Recommendation Report for Planning Permission for Works or Extension to a Dwelling

REF NO: AL/116/21/HH

LOCATION: Field Place
Nyton Road
Aldingbourne
PO20 3UA

PROPOSAL: Erection of part single, part two storey side extension with first floor rear balcony and 1 x front dormer, and front porch extension following the demolition of side link building and part garage

project: 21/C04
drawing no: 3b
date: Aug 2021

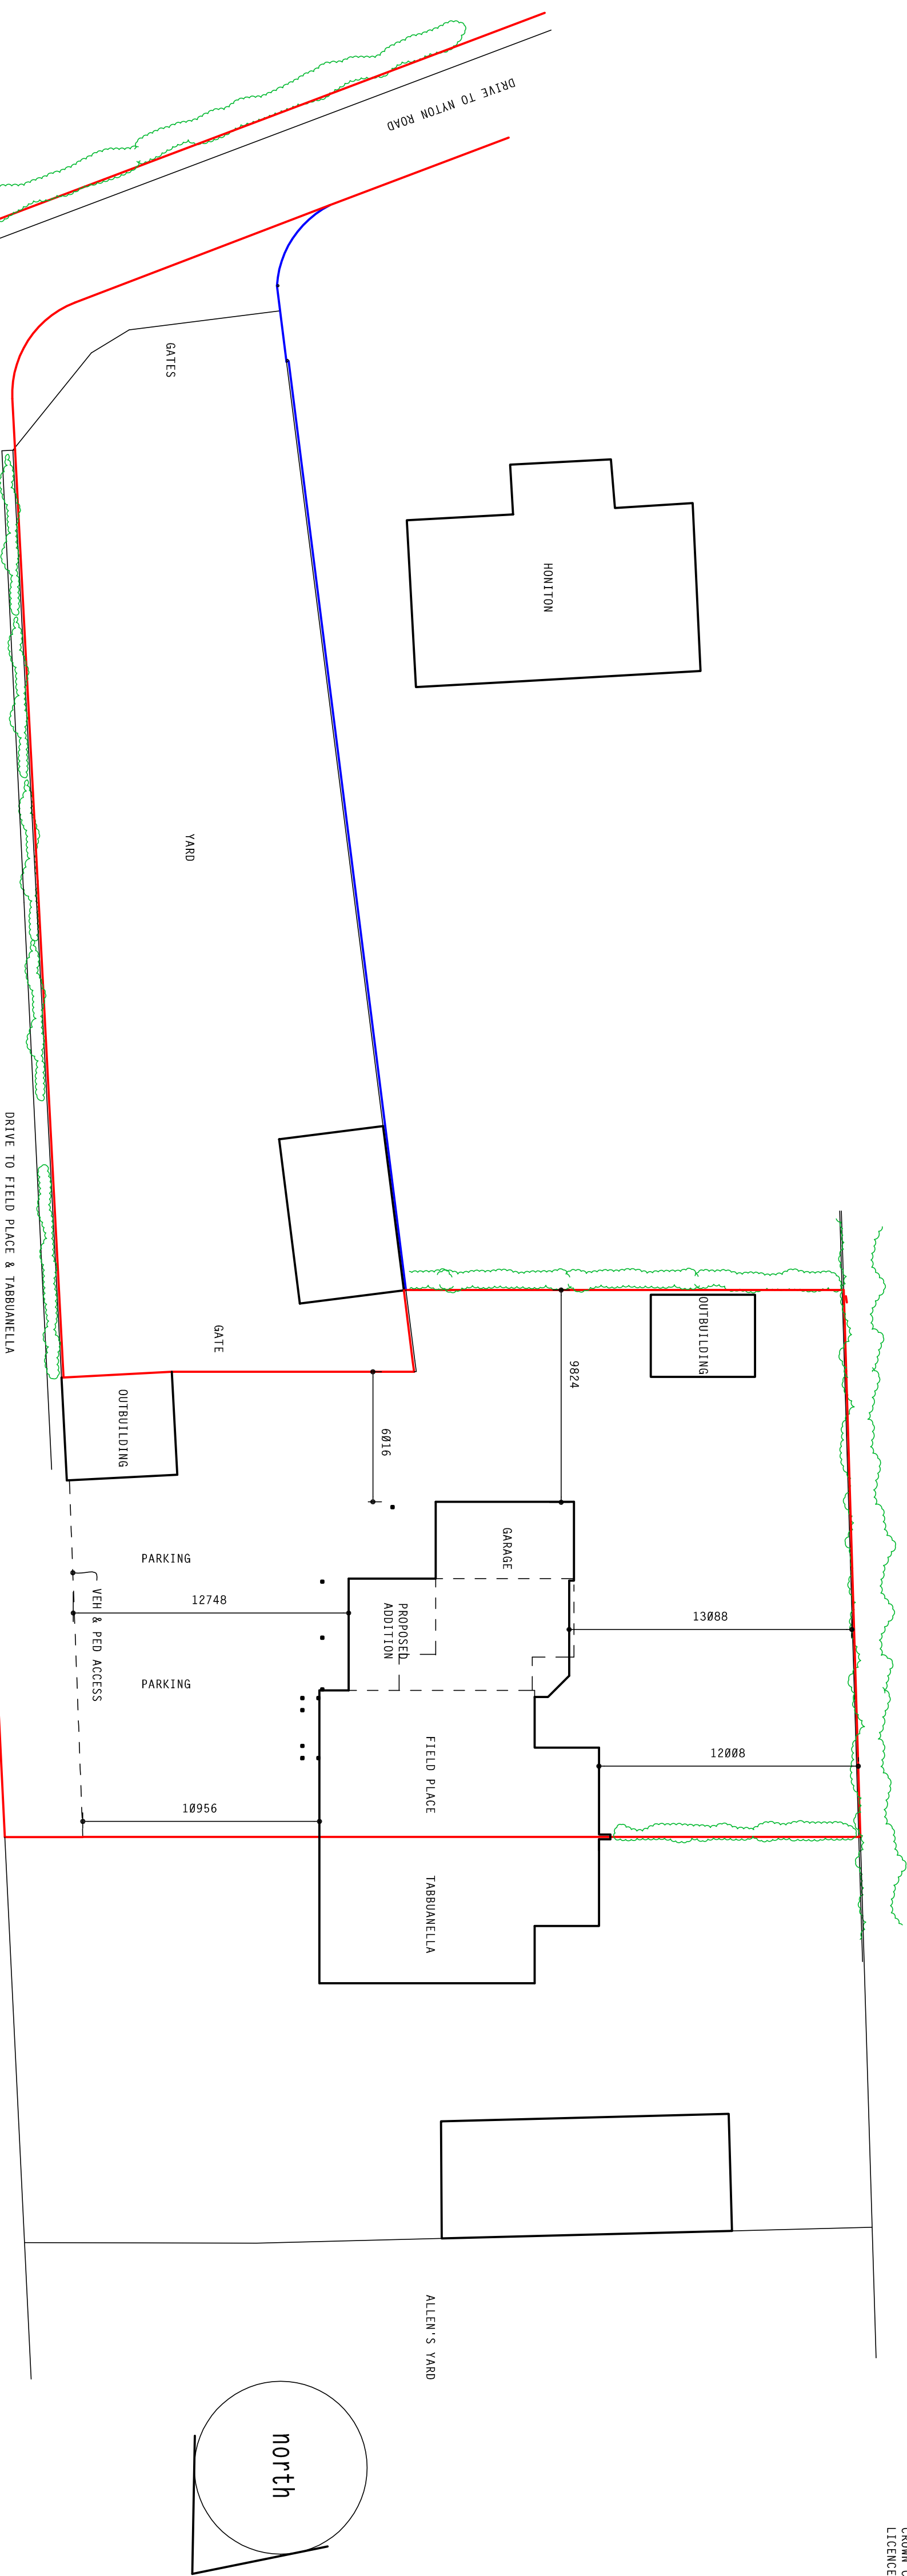
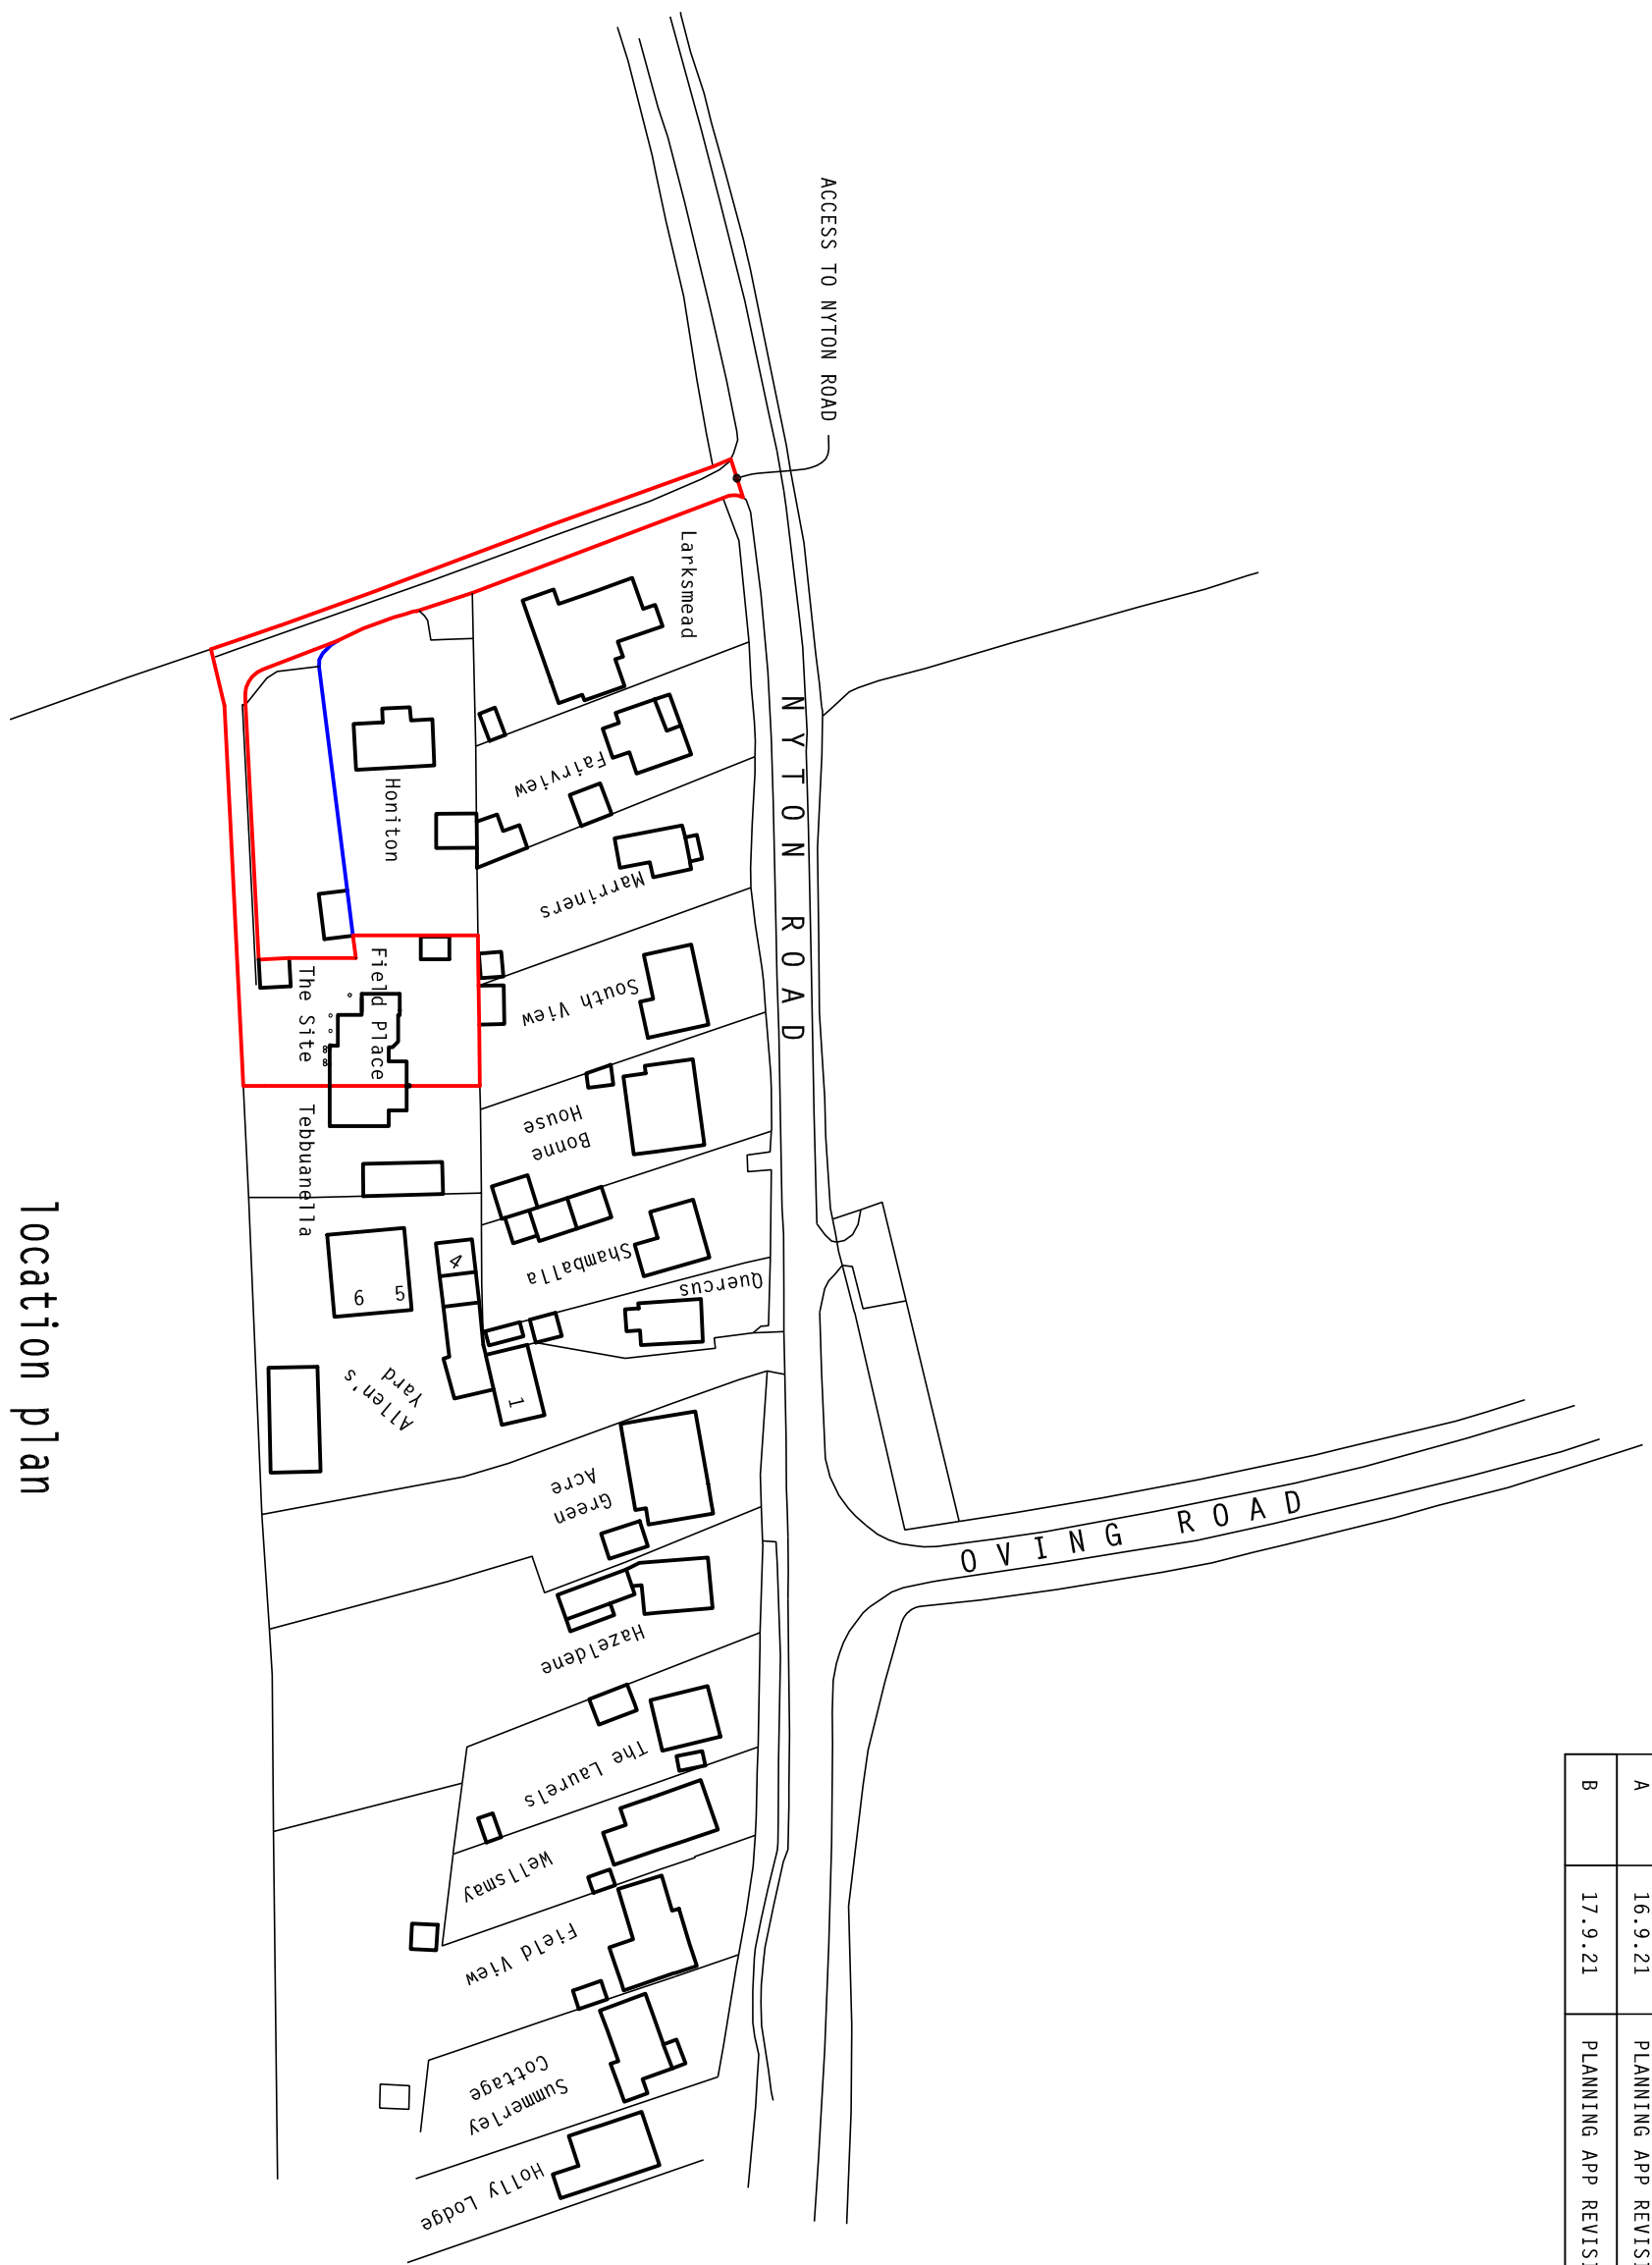
The side extensions retain 9.75m to the western boundary. This forms the rear boundary of the neighbouring property at 'Honiton' and as a result of the separation, the addition is not considered to result in adversely overbearing or overshadowing impact.

Views to the south east, will look towards the rear of 'Honiton' although with 13m to the boundary and a further 28m to the rear of the property, views are not considered significant.
